Subject: RE: BN/83/19/DOC and BN/94/19/DOC - Copsefield, Eastergate Lane, Eastergate.

Engineers Comments Regarding Surface Water Drainage

Subject: RE: Application BN/83/19/DOC

FORMPAVE PERMABLE BLOCK PAVING CONSTRUCTION

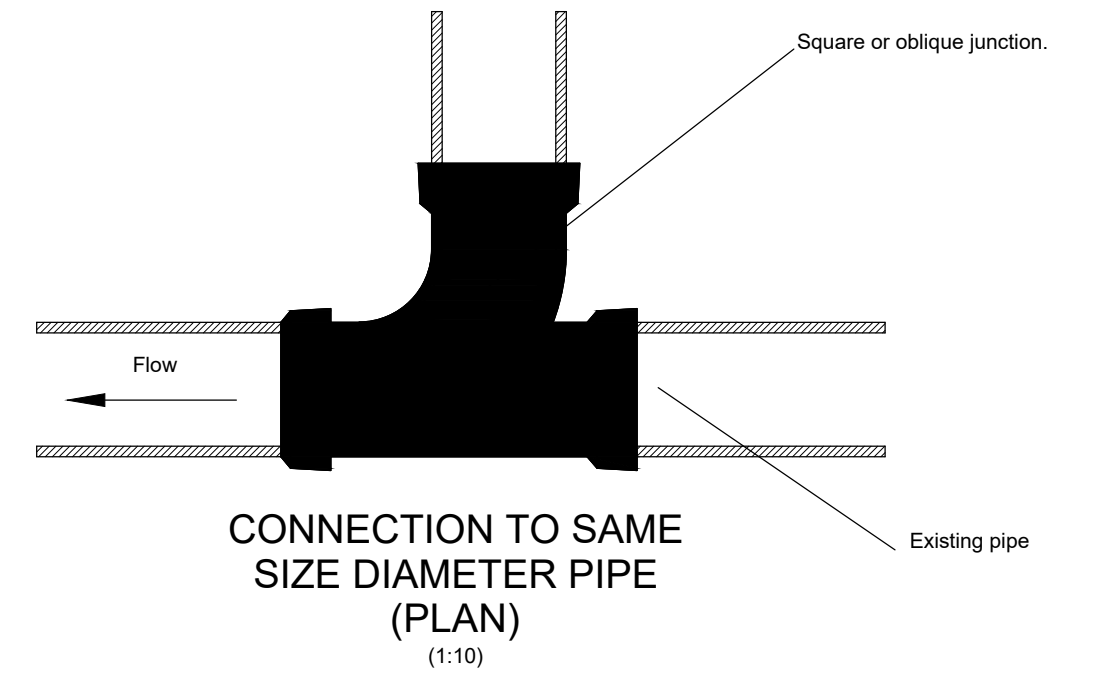
1. I have now tested the proposed soakaways on two programs, both of which have them surcharged (slightly) for a 1 in 100 year +40% event.
2. The applicant will need to submit calculations for the permeable paving. Alternatively they can choose to direct the surface water to the soakaways and upsize them with amended calcs. If they choose to infiltrate through the paved area then they will need to consider putting in check dams to prevent the water cascading to the lower levels as the site has a significant slope. Alternatively the base can be formed flat but this will require more stone. Either option will need to be shown in detail drawings.
3. The 5/20 stone is acceptable as long as it is free from fines and achieves 30% voids.

It is recommended that condition 4 (relating to surface water drainage) applied following approval of application EG/50/16/PL be discharged. Please ensure that the following documents are uploaded to the public portal and that the development is constructed in accordance with them:

Please find revised drawings and calculations attached.
